Appeal NO: ABP 319281-24

Our Reference: FPL/912/03081
Your Reference: ABP-319281-24

Our client: Killineer and District Residents Association

RE: Construction of approx. 5,719 sq. m. gross floor area (GFA) main building to house hot dip metal galvanising plant and all associated site works. An Environmental Impact Assessment Report (EIAR) and Natura Impact Statement (NIS) were submitted with the application. The proposed development will require an Industrial Emissions (IE) Licence under the EPA Act 1003, as amended

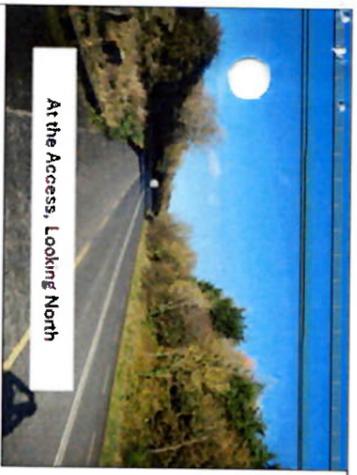
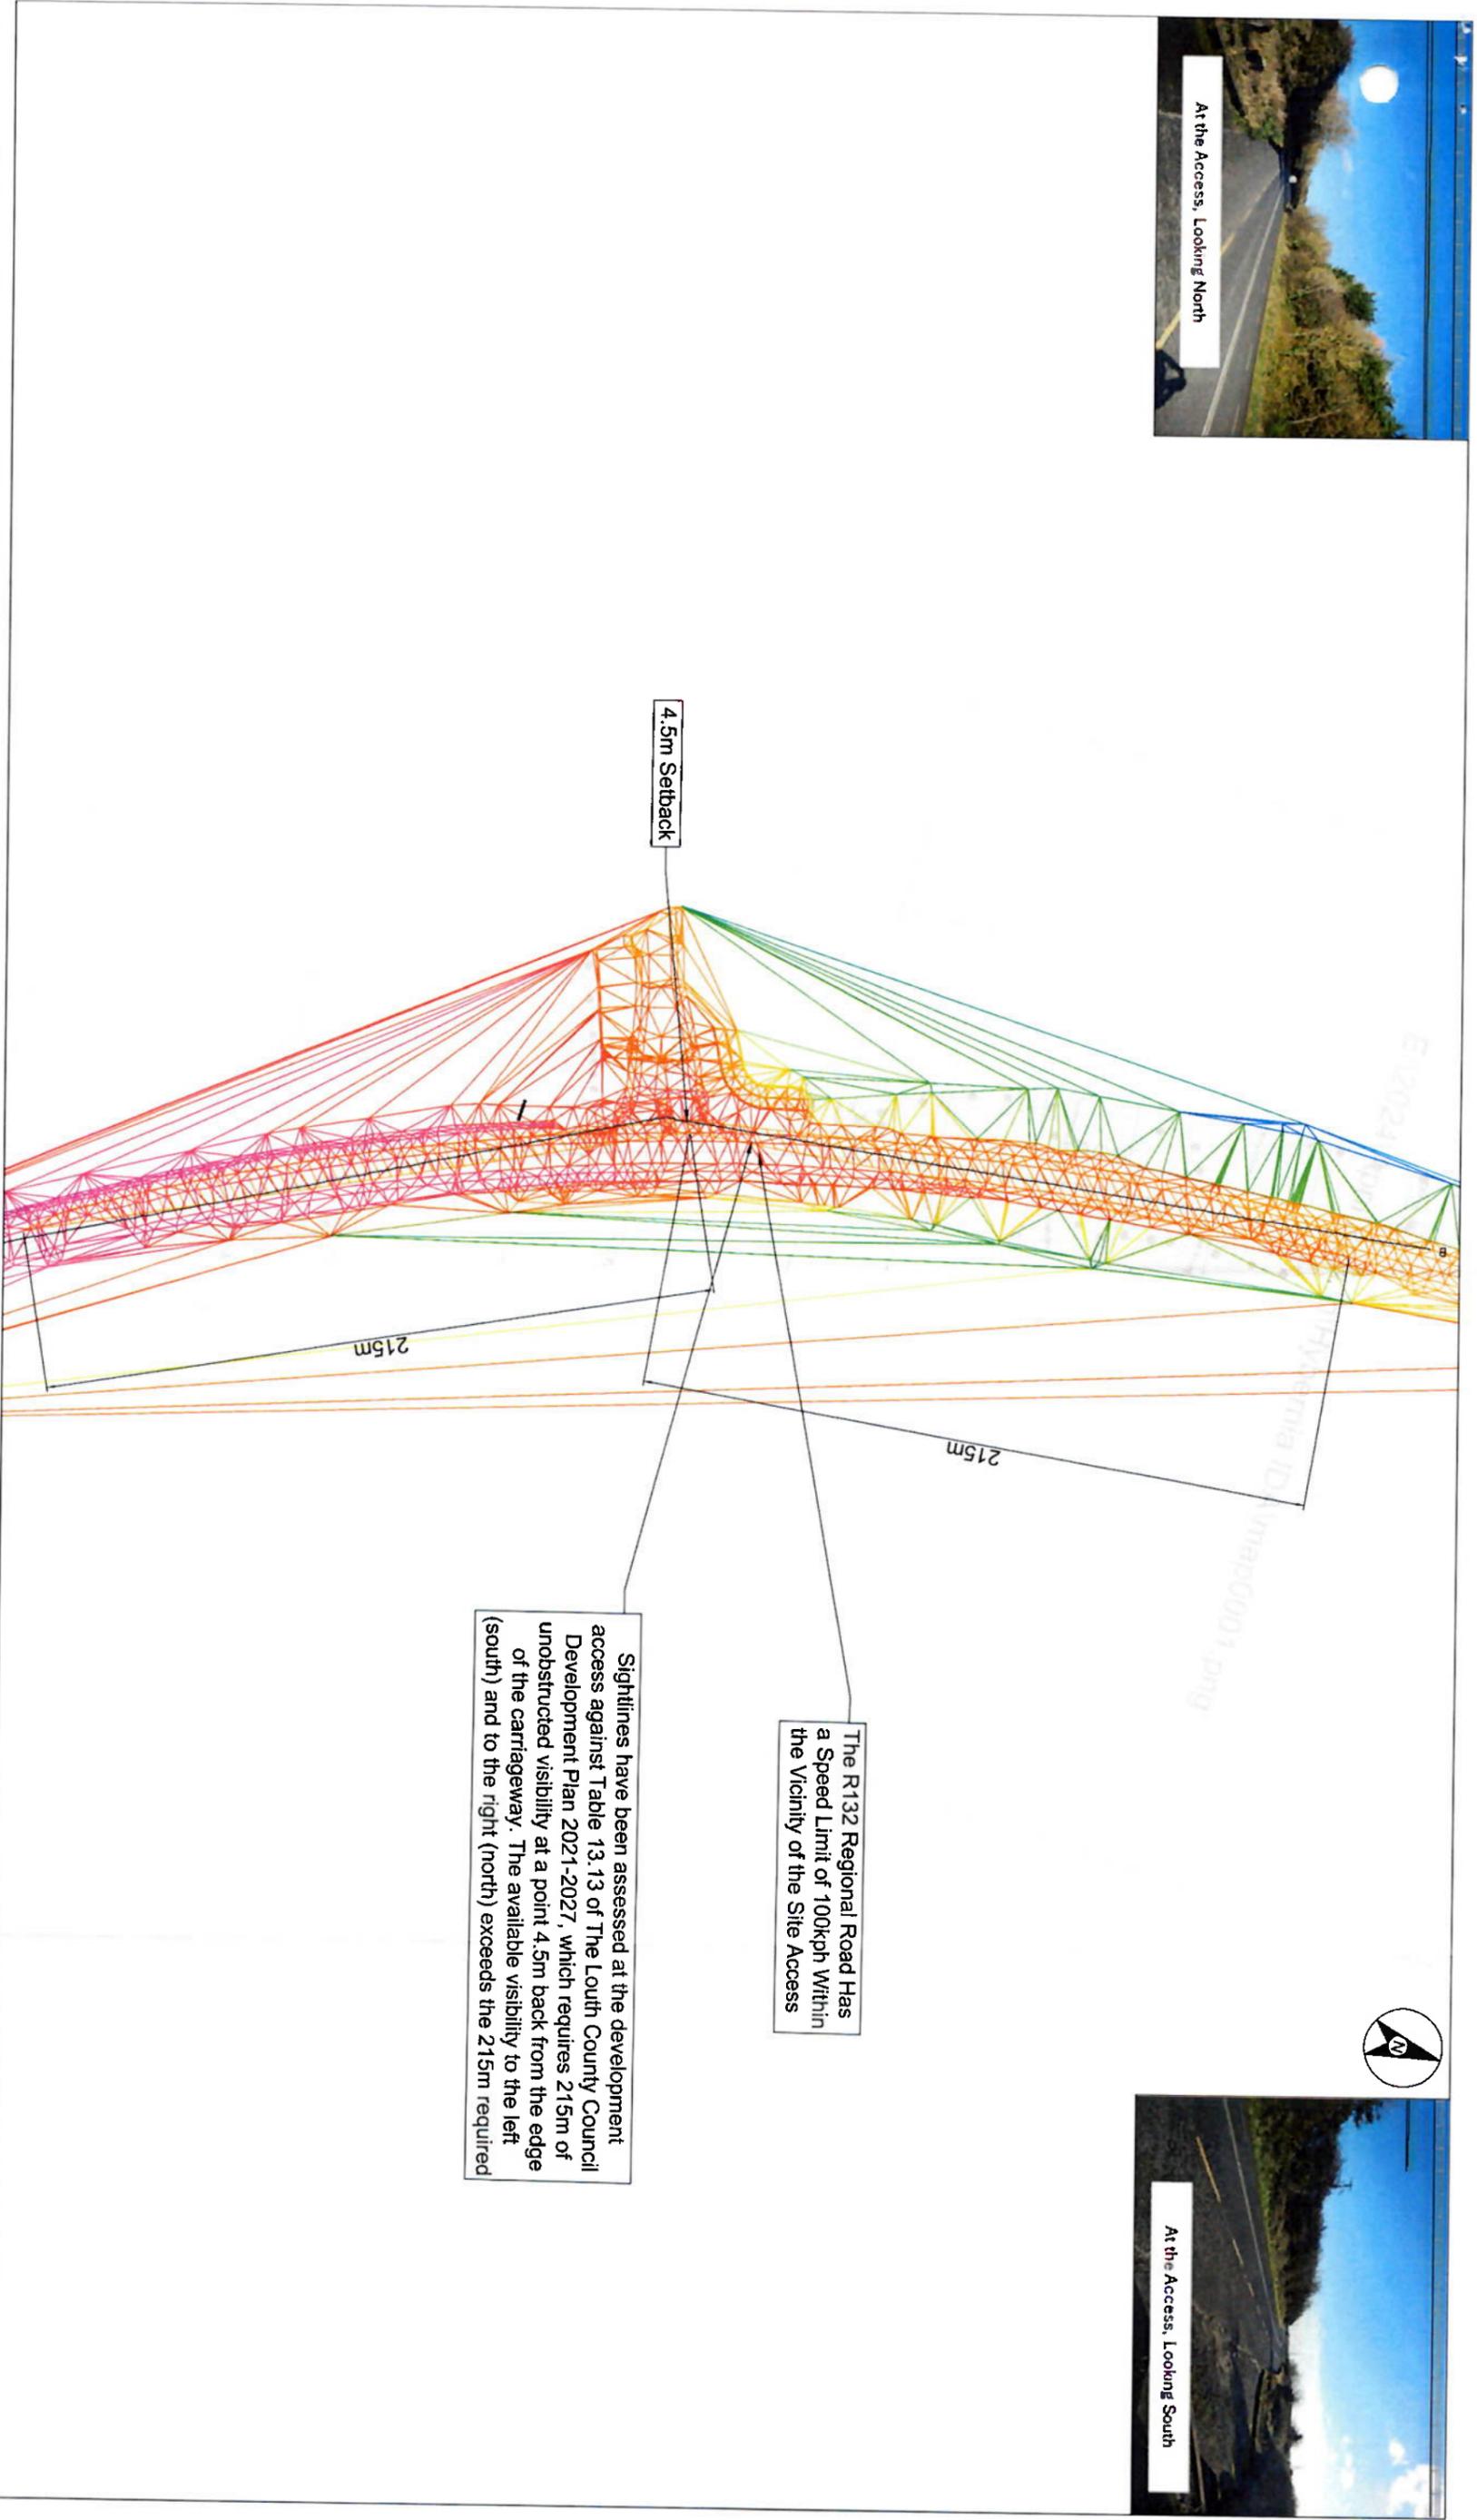
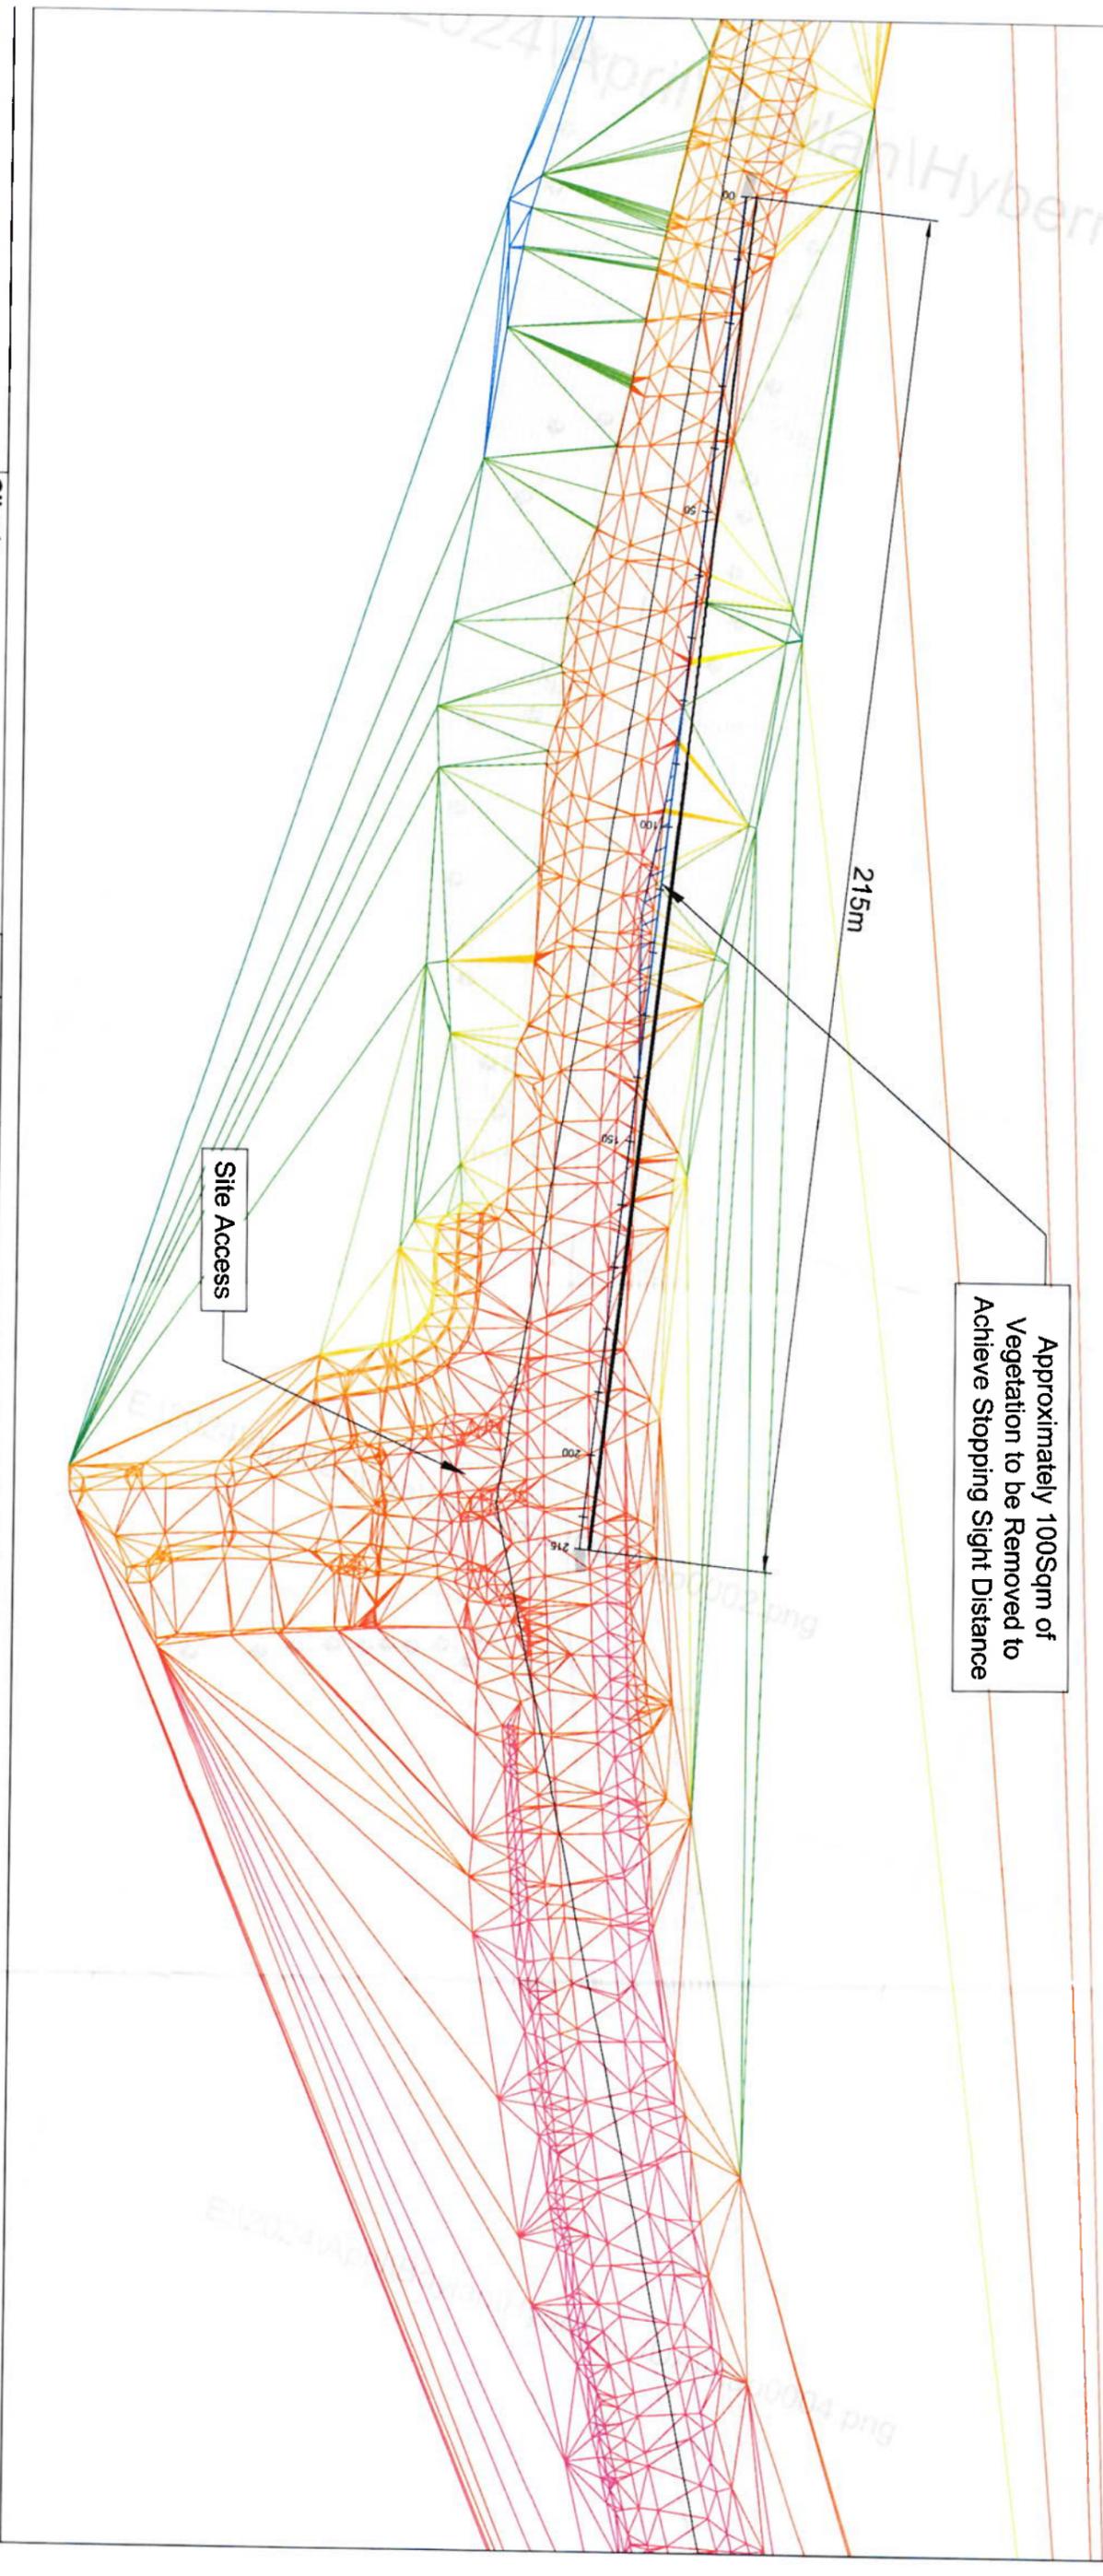
16. It appears that there are issues with sight lines and that there is a requirement for works outside the blue line to maintain safe compliant sight lines. The condition suggested at paragraph 3.59 is *ultra vires* the Board since it is impermissible for it to impose a condition on a third party, whether a private or public entity, requiring the third party to carry out works. Equally no evidence has been shown that Louth County Council does in fact own the land where these works are to take place. The LDA land ownership map is not evidence of title and cannot be relied upon for that purpose.
